MEMORANDUM

240182 – SYD086 SSSA 73761707 - PWNA Response – R1

COMPANY: LCI
FROM: Nikolaj Drydale-Cech
SUBJECT: Response to comments

Response to the EPA comments

Figure 18 Operational Scenario 08 - Proposed daytime emergency generators / load bank positions (in addition to mechanical services).

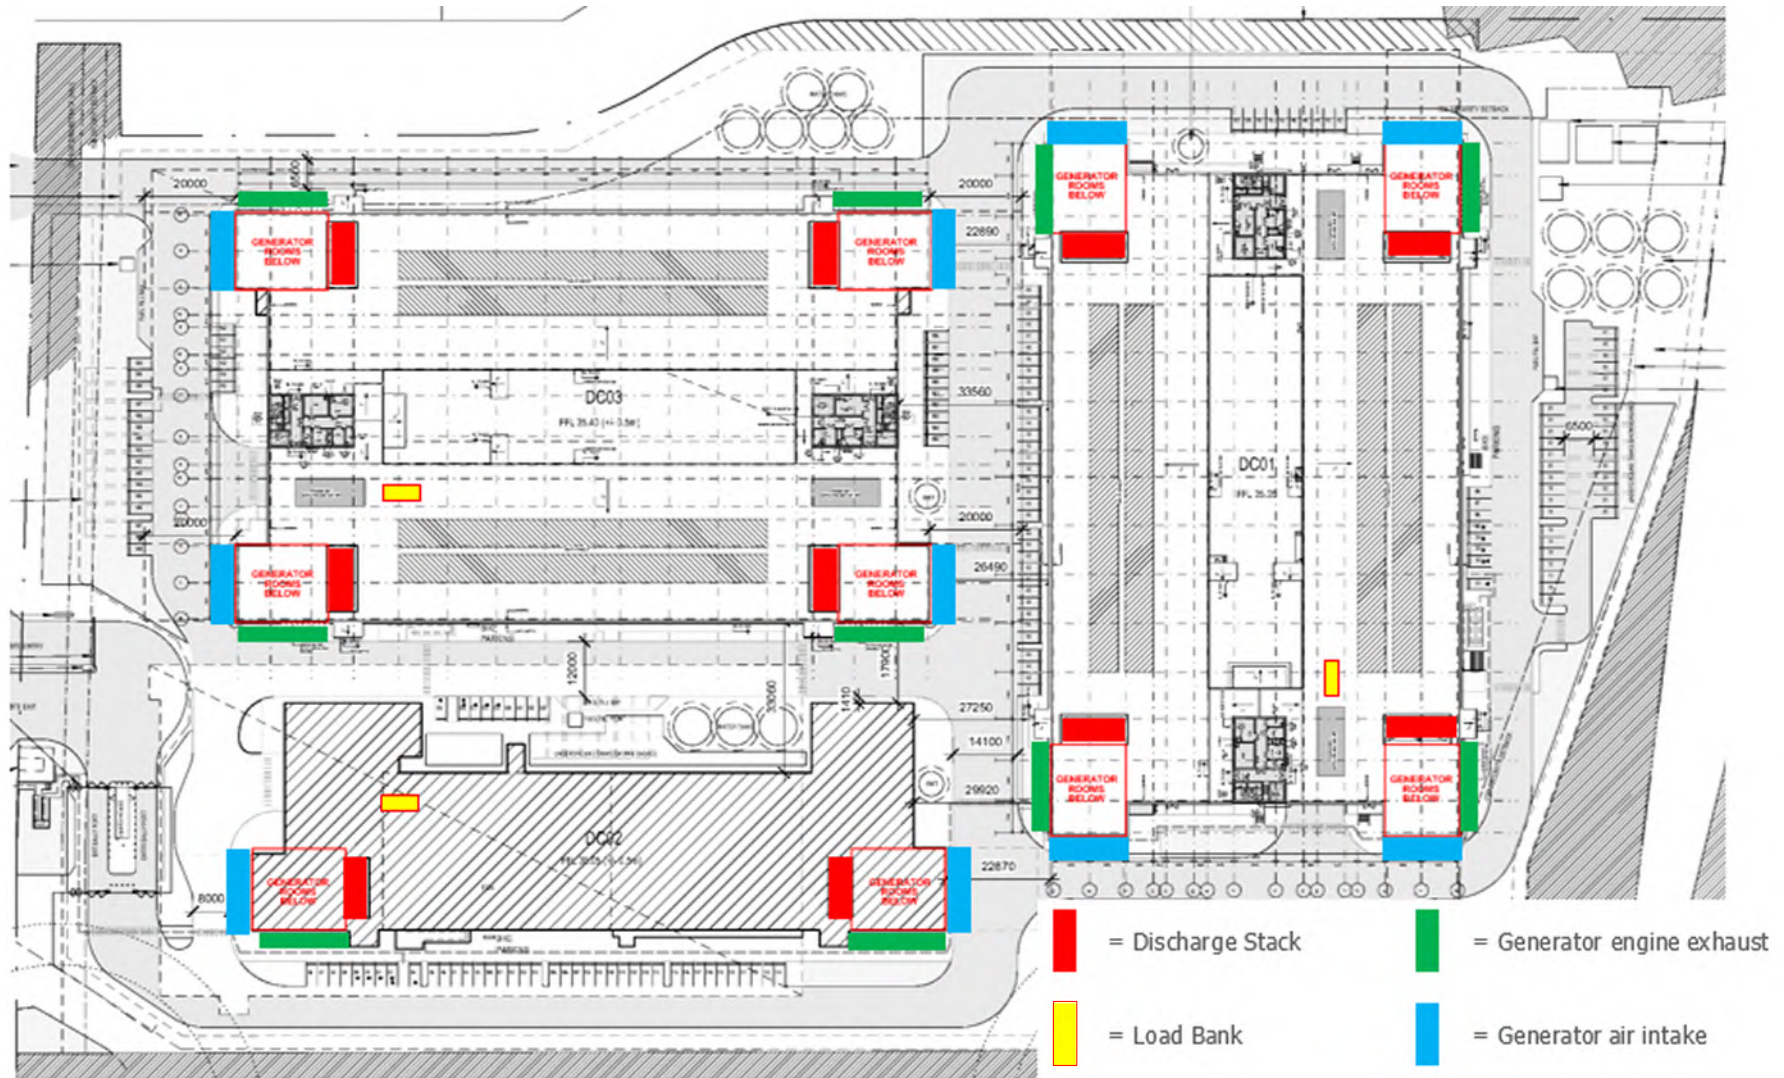
Section 5.6 is unclear on whether the third-octave measurements taken to inform the assessment of low frequency noise includes the operation and testing of the emergency generators. Annoying characteristics from noise associated with all activities undertaken on the premises are to be assessed.

Recommendation: The EPA recommends that DPHI request the Applicant to clarify whether all relevant noise sources associated with the proposal have been included in the assessment of annoying characteristics of noise.

The low frequency assessment section has been revised to include a detailed analysis of low frequency noise impacts for all considered receivers for the daytime generator testing scenario (Operational Scenario 08) which represents the scenario with the greatest potential for low frequency noise impacts.

The assessment concluded that none of the noise sensitive receivers were found to exceed the low frequency screening criteria. Hence, no further consideration of the unbalanced spectrum is required.

**2 Glendenning Road, Glendenning Data Centre Campus SSDA 73761707**  
**Operational Scenario 05 Evening**  
 $L_{Aeq,15 min}$  noise impacts  
 Contour Height 1.5 m

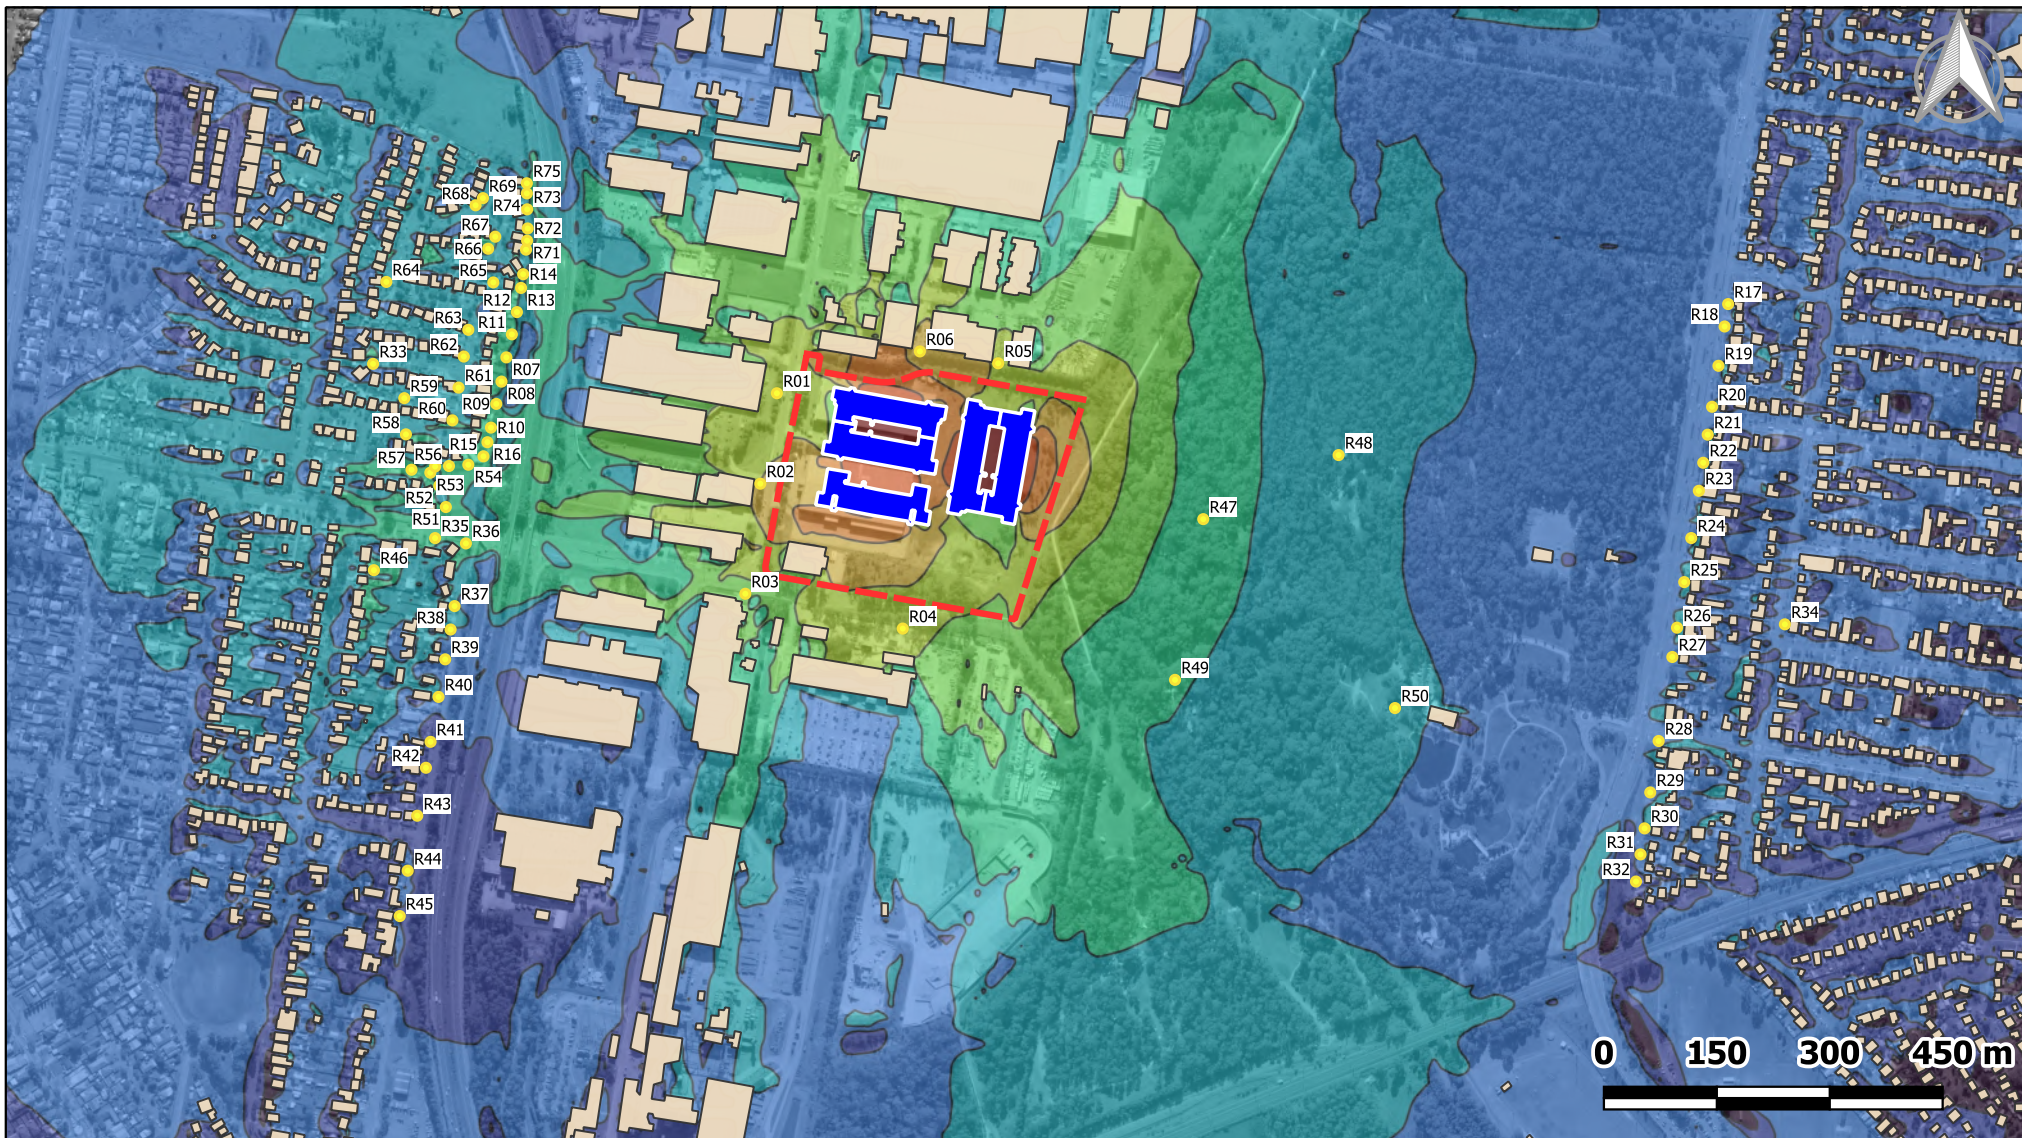
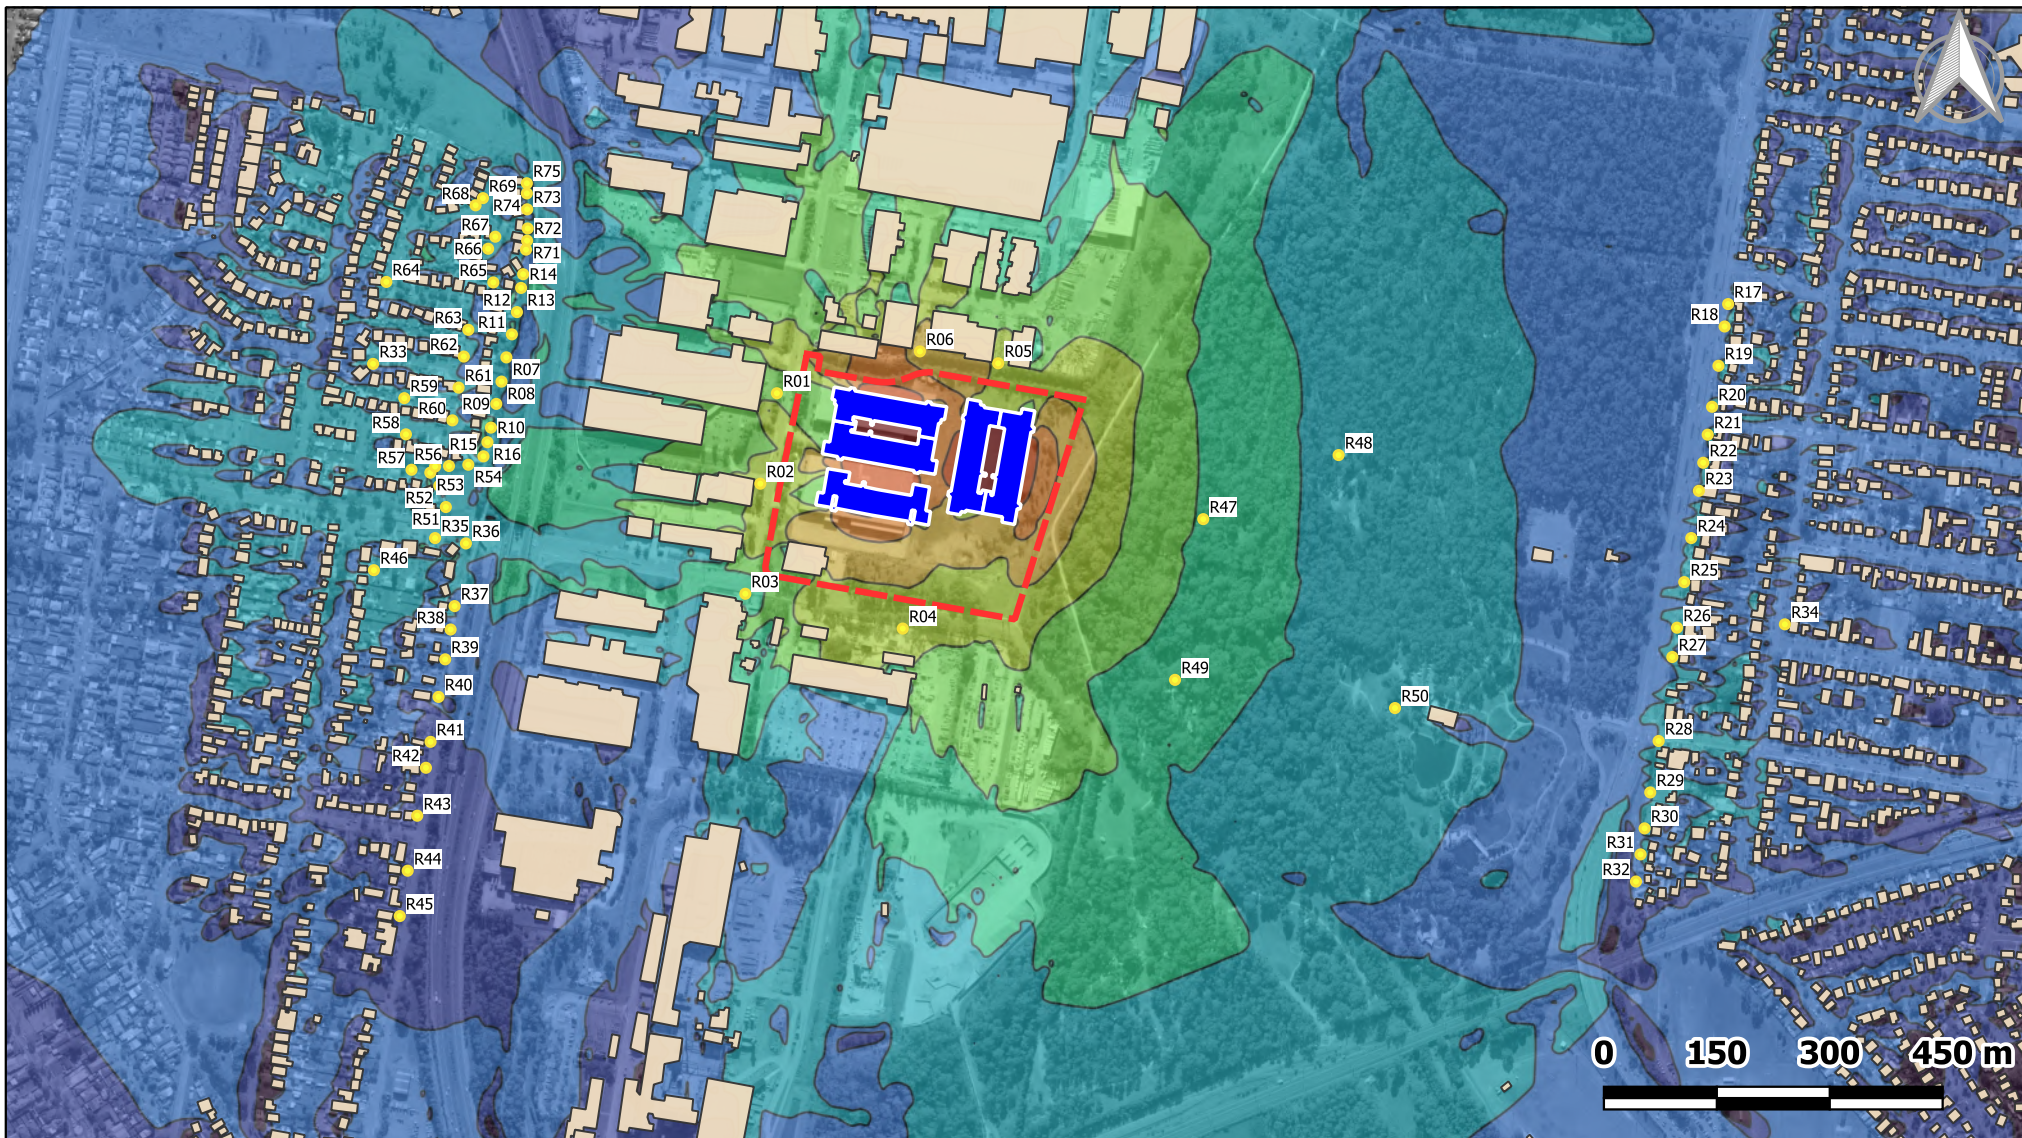
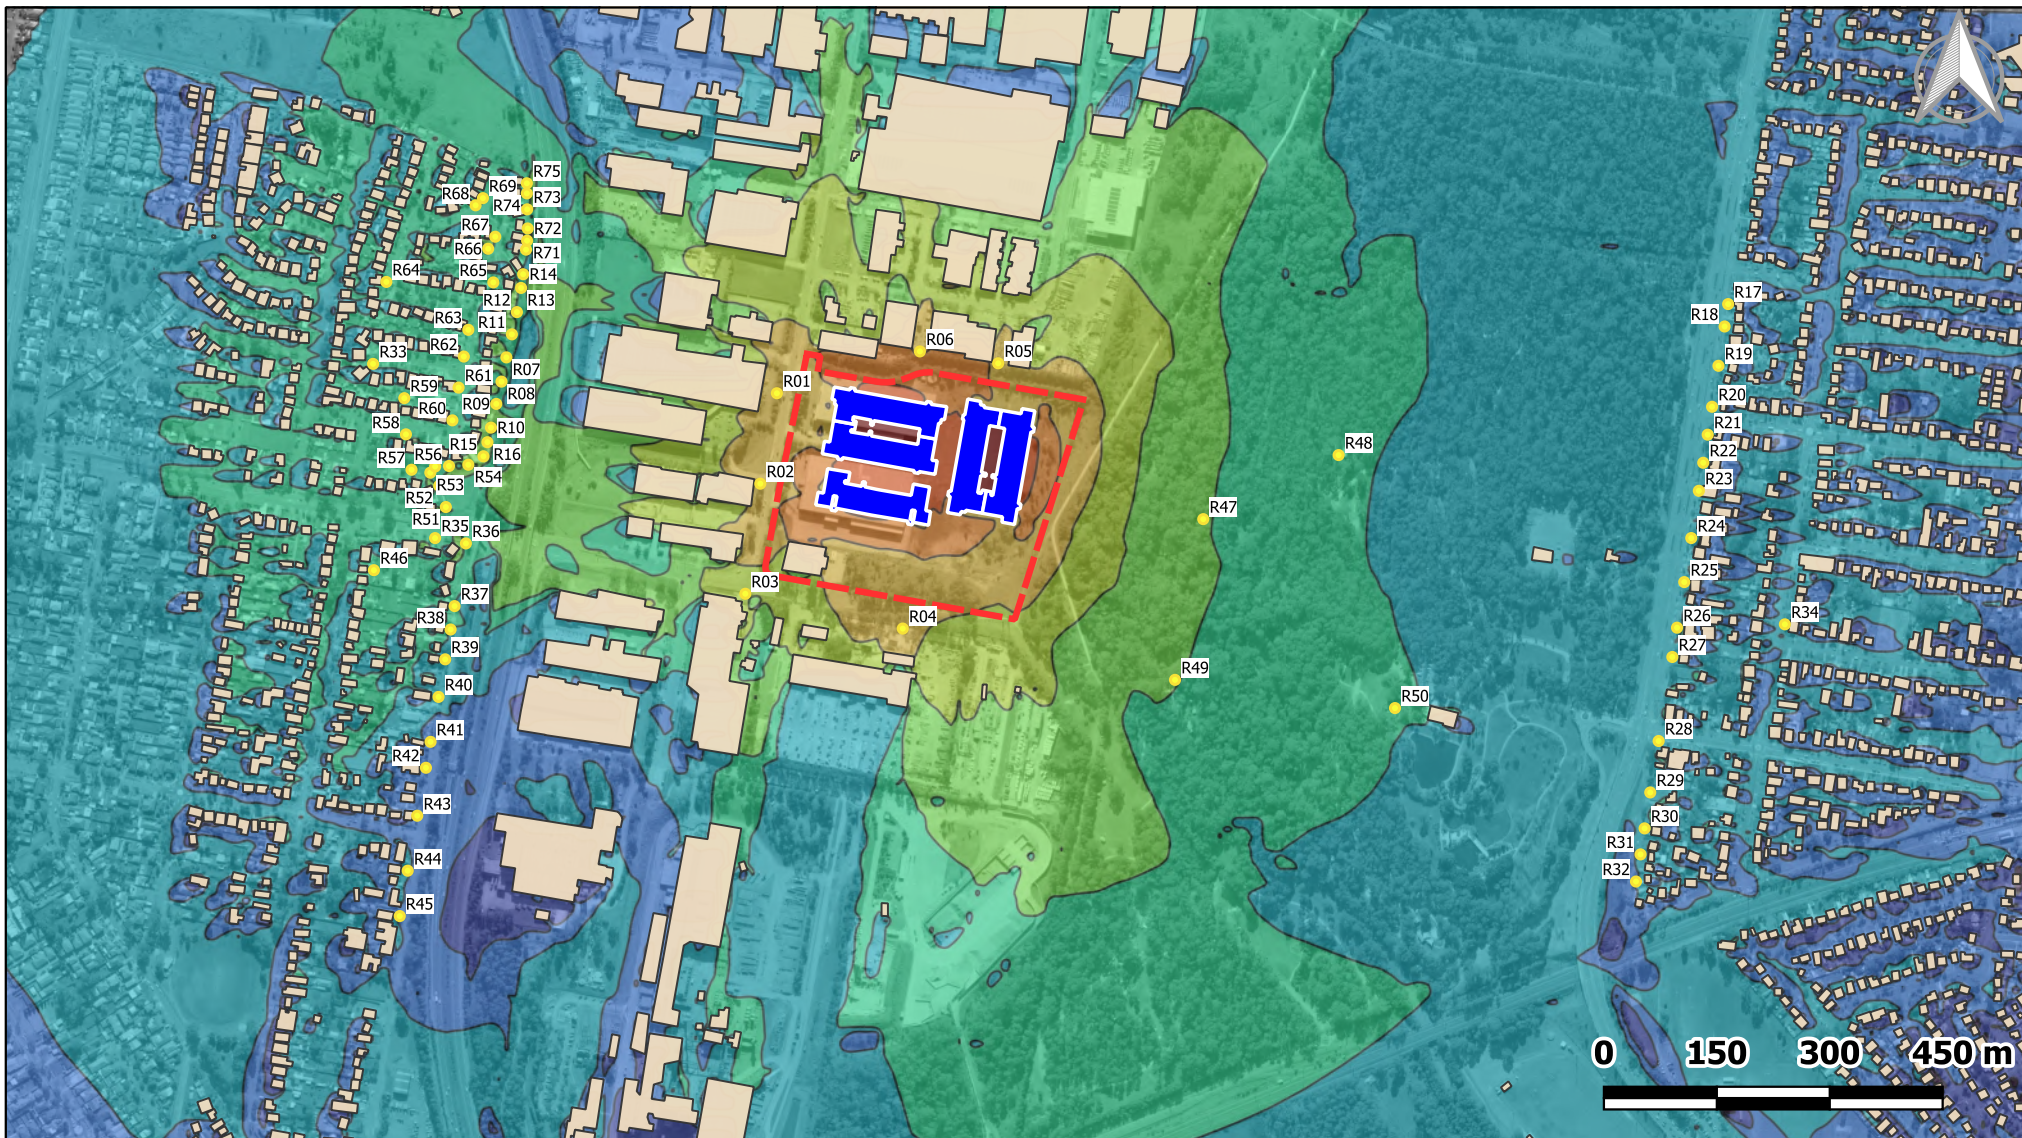
Under Section 5.4, the descriptions of Scenarios 4 and 5 state that "The modelled location of the generator / load bank represents the worst-case assessment for this scenario. The modelled generator / load bank location is not intended to restrict generator testing operations to this one specific location." The modelled generator is presented in Figure 13 as located in the northwestern corner of the proposal. While this appears to be the worst-case assessment scenario for NCA 1, for NCAs 2 and 3 the worst-case generators are likely to be different due to their different orientations to the premises. As the generator testing is not intended to be restricted to that one specific location, the assessment indicates an unknown level of risk, which should be addressed by further consideration of the worst-case configuration for NCAs 2 and 3.

Recommendation: The EPA requests the Applicant provides the predicted noise levels for the worst-case generator testing scenarios proposed.

The updated NVIA includes separate operational scenarios (Operational scenario 05, 06, and 07) with both quantitative noise emissions and contour maps for each data centre that is proposed to operate with a generator and load bank during the evening period. These considered scenarios represent the worst-case scenario for each NCA during the evening period.
